DECISION DELEGATED TO HEAD OF PLANNING

Application No: H18-0863-22 **Applicant:** Mr J Lavender
Proposal: Extension & alterations
Location: Lavender Corner King John Bank Walpole St Andrew
Terminal Date: 27th October 2022

CASE OFFICER ASSESSMENT

DRAWING TITLE
PROPOSED FLOOR PLANS AND ELEVATIONS
WITH SECTION

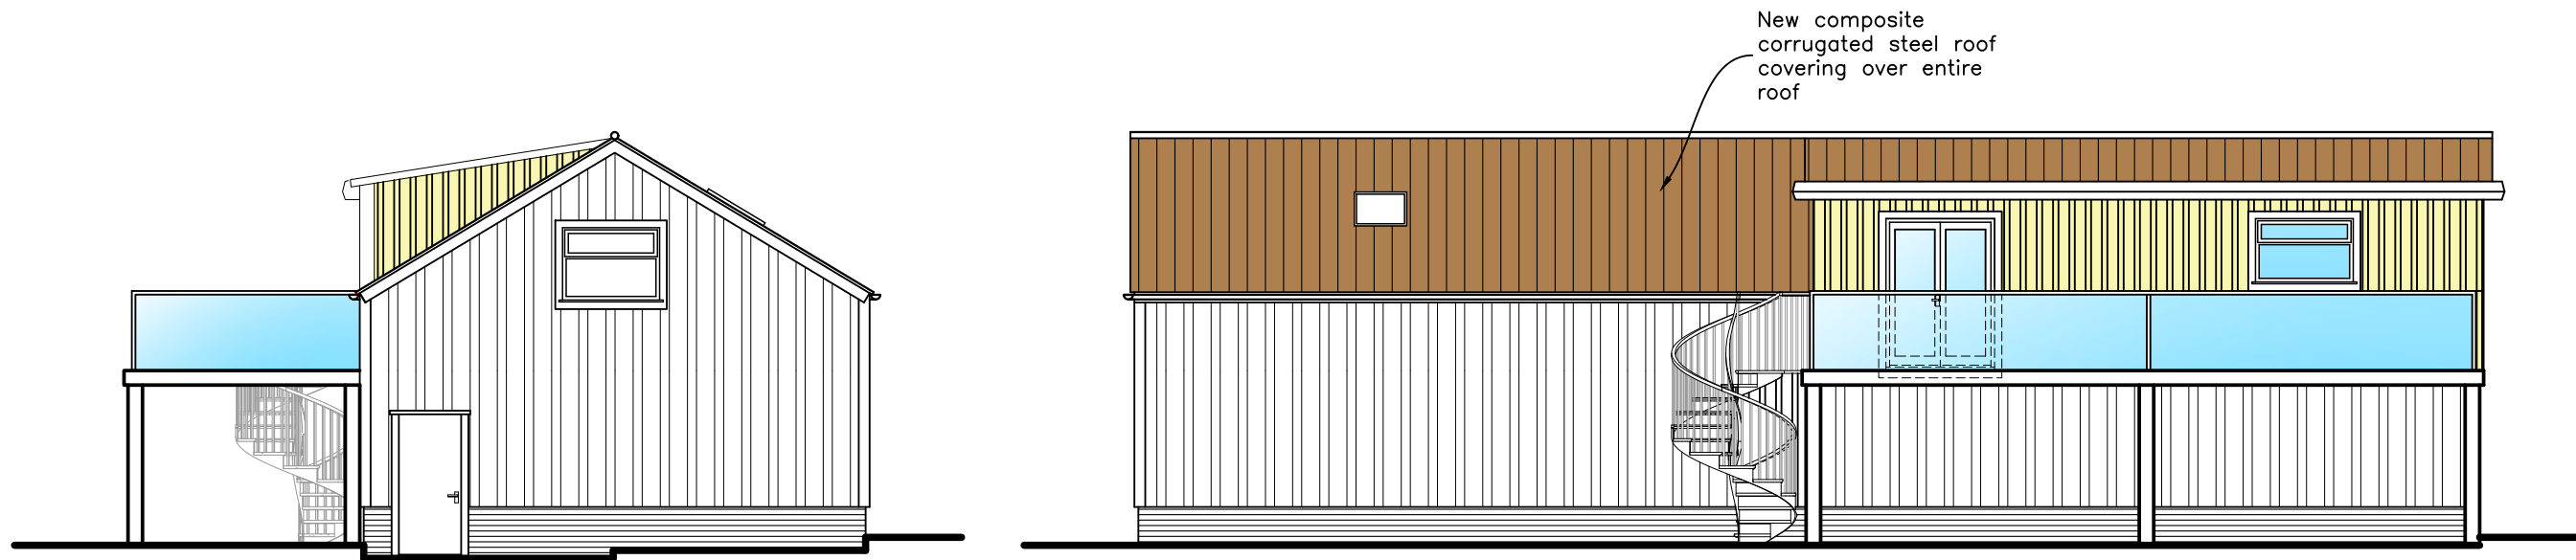
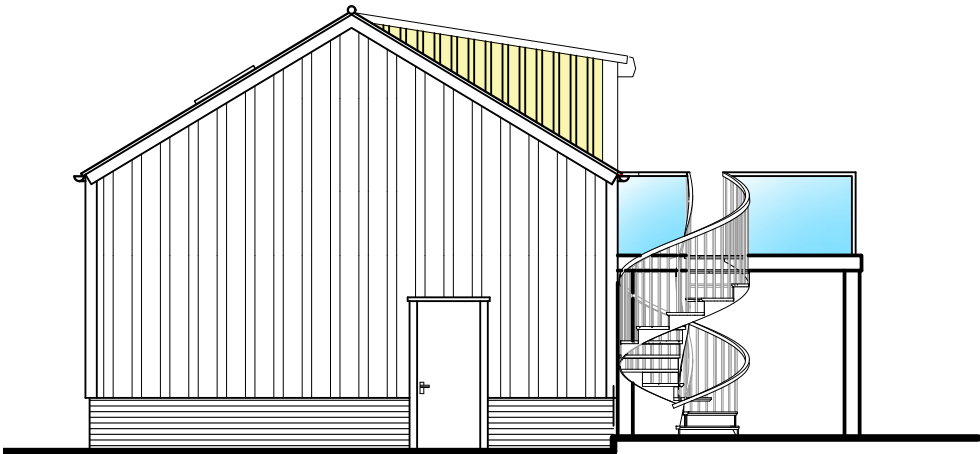
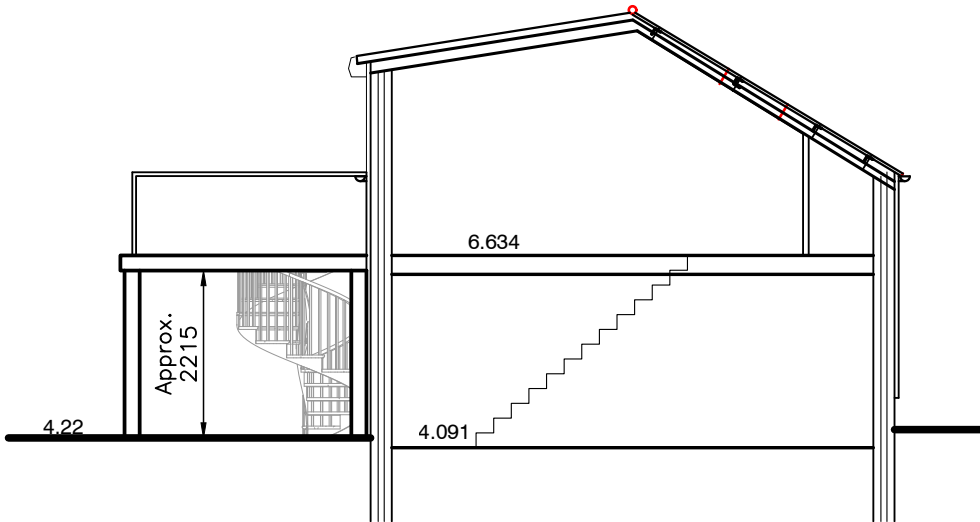
The outbuilding to the north-west of the dwelling can be seen from the north and west of the site and there are also glimpsed views from King John Bank. The proposed replacement roof would be similar in appearance to the existing and would improve the overall appearance of the building.

The proposed extension to the outbuilding is not considered ideal in terms of its design/appearance, however, it would not be visible from the public realm as it would be sited in the rear garden and blocked by the existing house and the outbuilding therefore it can on balance be accepted as it would not impact the character of the area.

PART GROUND FLOOR PLAN - 1:50
MAIN ENTRANCE - HOUSE

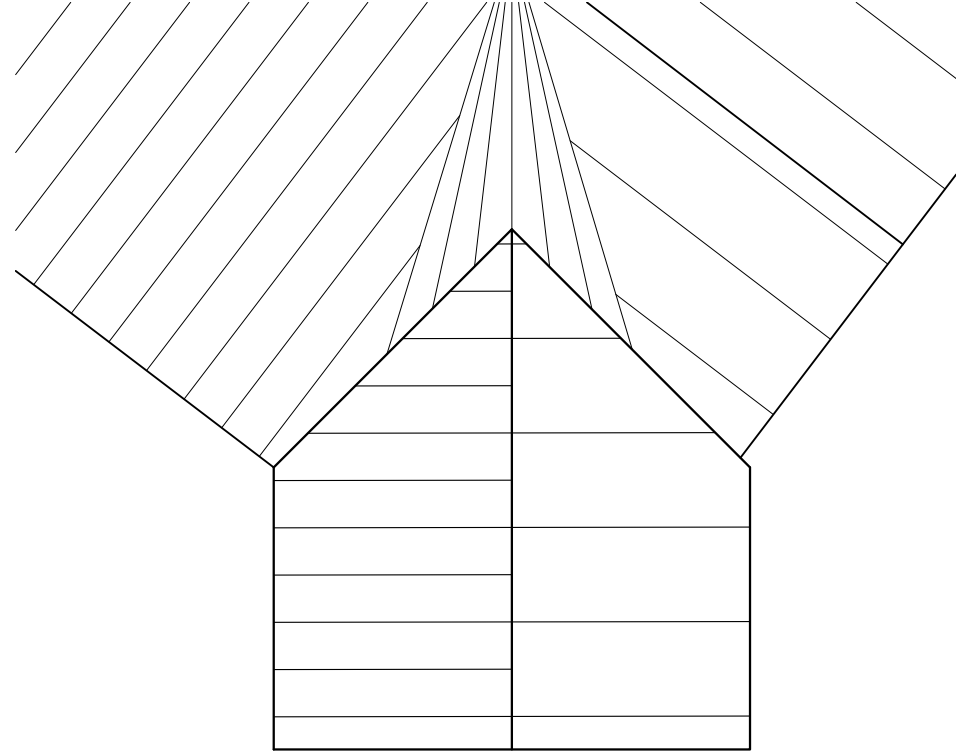
The proposed porch element would be visible from the public realm, however, given its minor footprint and relationship with the existing house it would not appear overly prominent in the street scene.

BLOCK PLAN - 1:200
PROPOSED

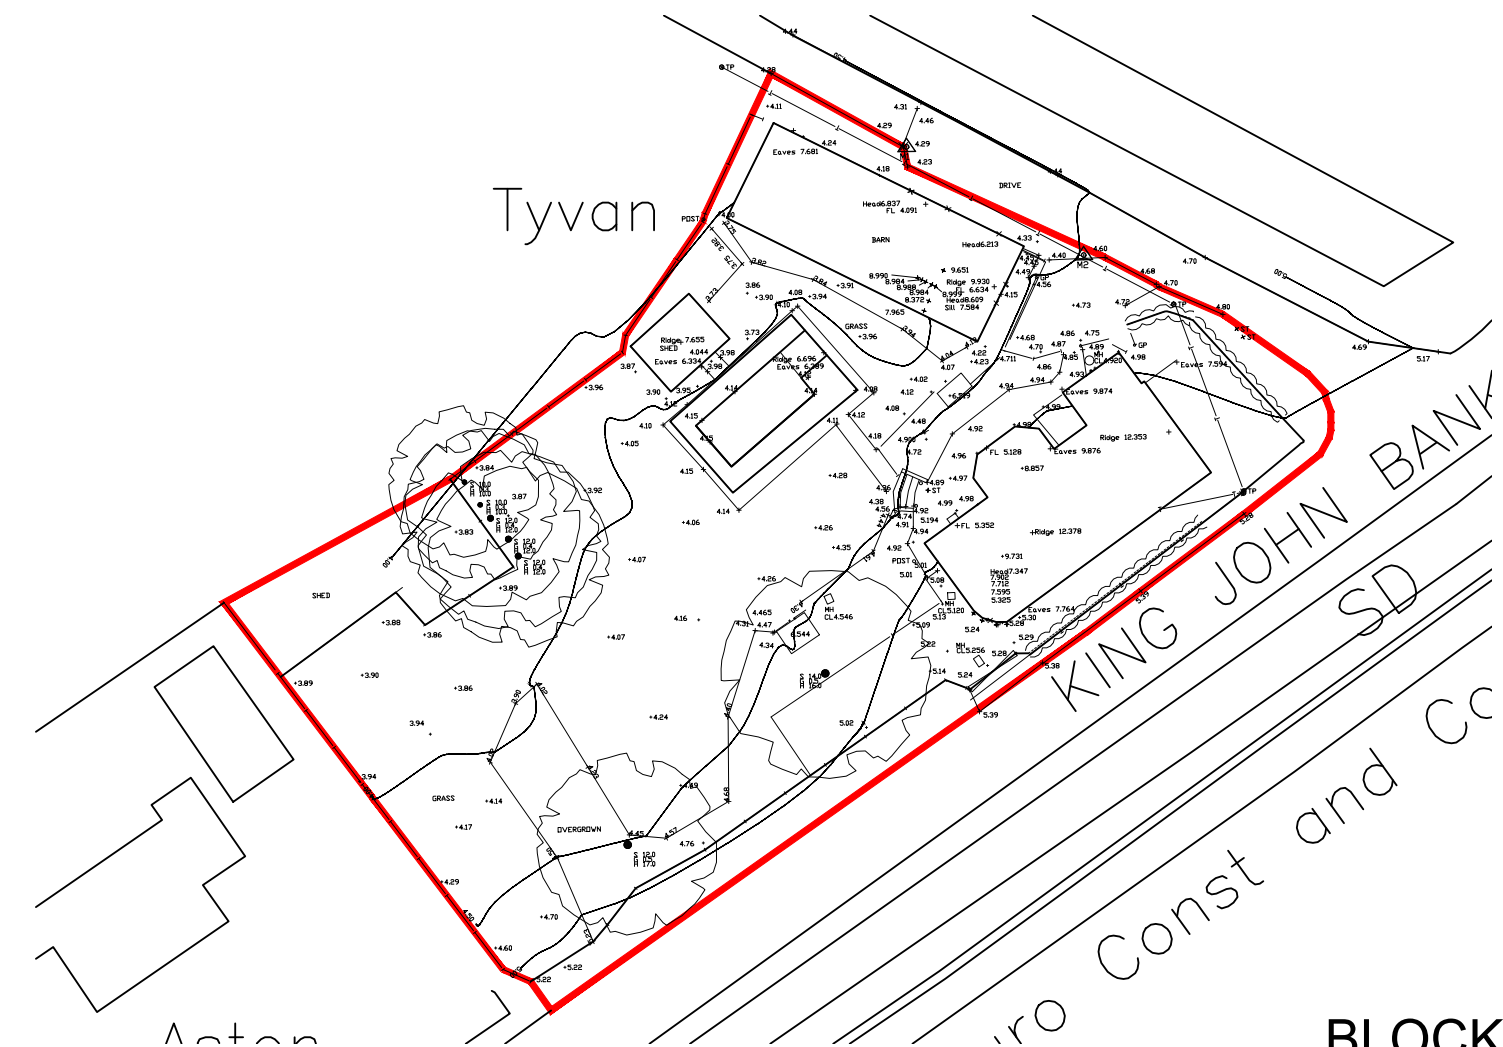
With regards to the proposed decking and landscaping alterations in the rear garden, these can also be accepted as they are not considered to significantly or unacceptably change the overall appearance of the site.

CARPORT LAYOUT PLAN - 1:50

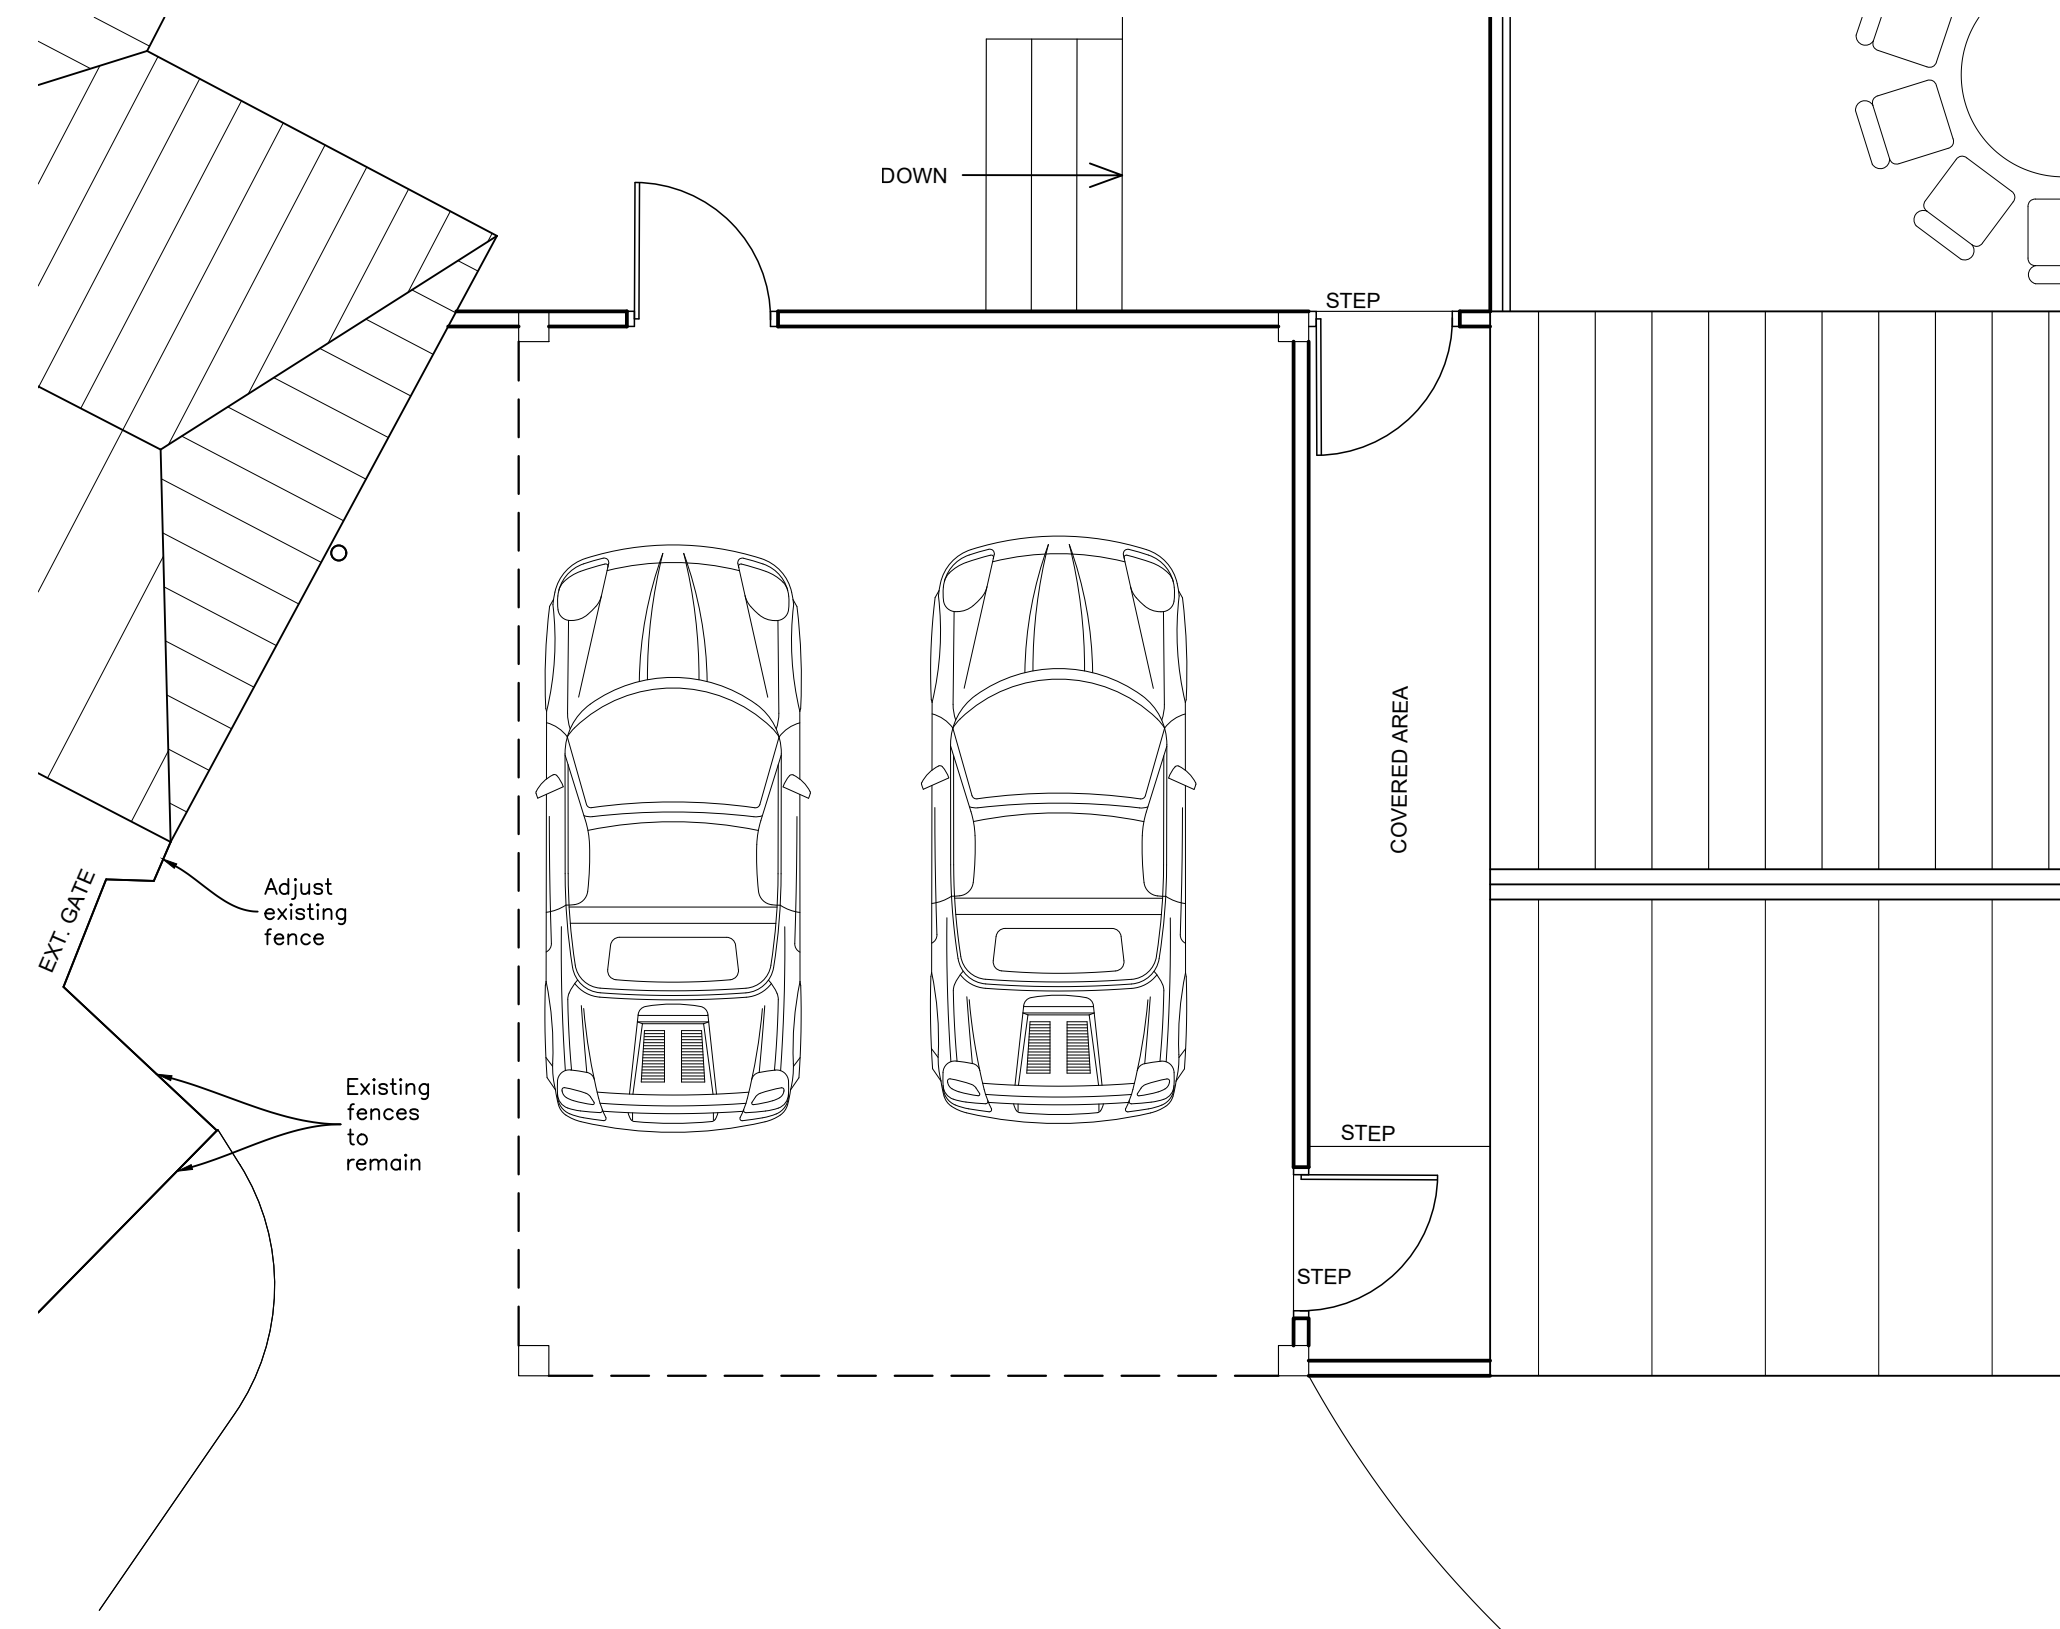
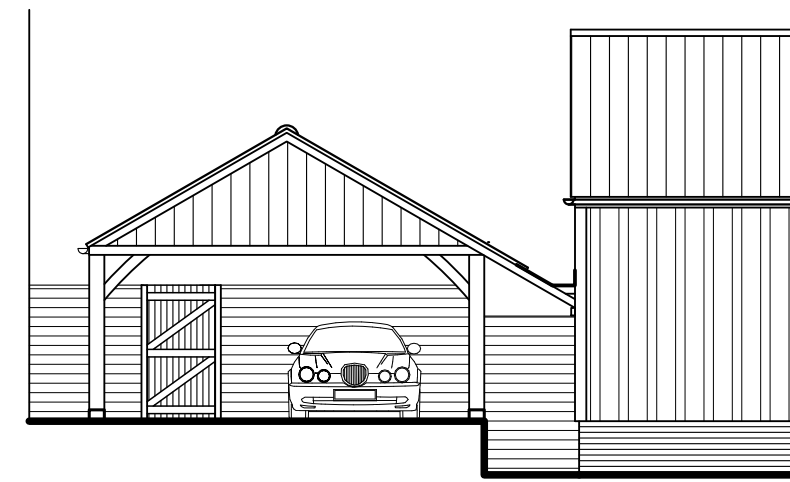
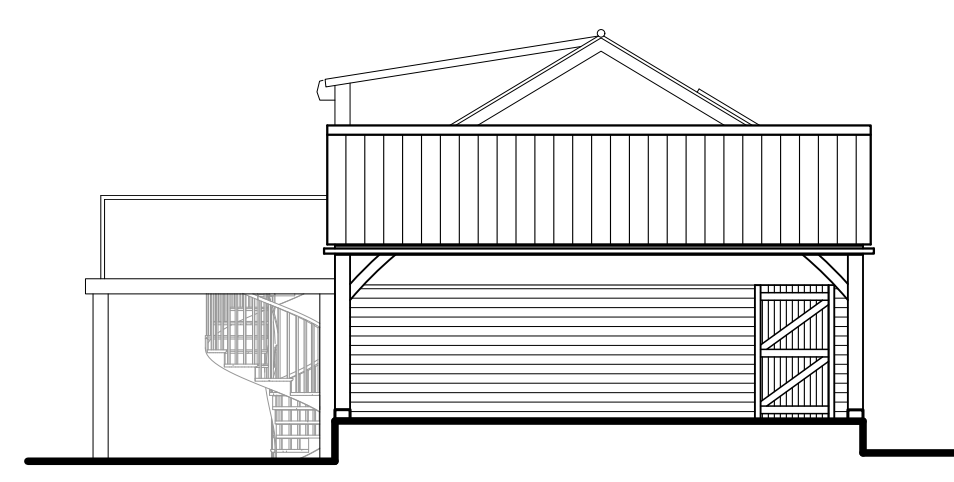
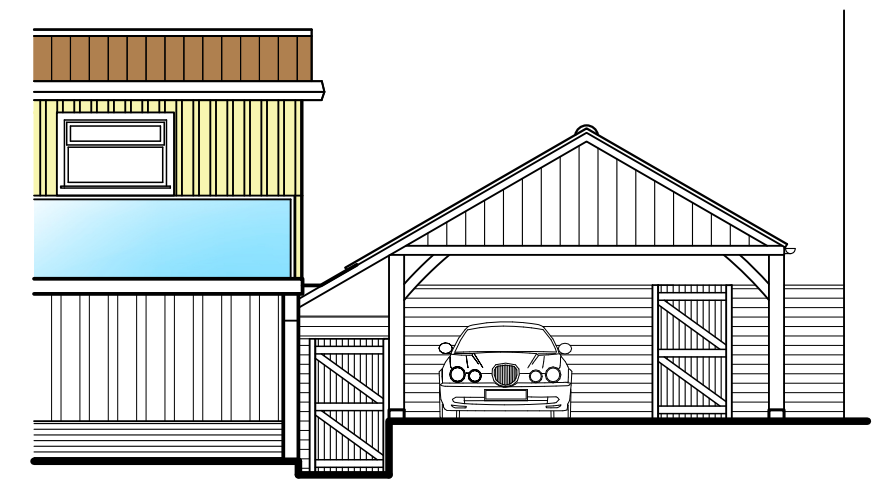
The proposed carport would in effect infill the gap between the main house and the outbuilding. There may be glimpsed views of this from King John Bank, However, given its set-back from the road

and modest height, it would not appear overly prominent in the street scene.

In conjunction with Policy 36 of SELLP 2019, Appendix 6 sets out the minimum standards for parking provision upon the use class. It is not clear how many bedrooms the property has, however, a maximum of 3no off-street parking spaces are required for the site. The proposed carport would provide 2no spaces and meets the size requirements for covered parking spaces. The site does not currently have formal parking provision therefore the proposed development is considered to somewhat improve the parking situation, albeit it may be short of one parking space. As such the proposal can on balance be accepted.
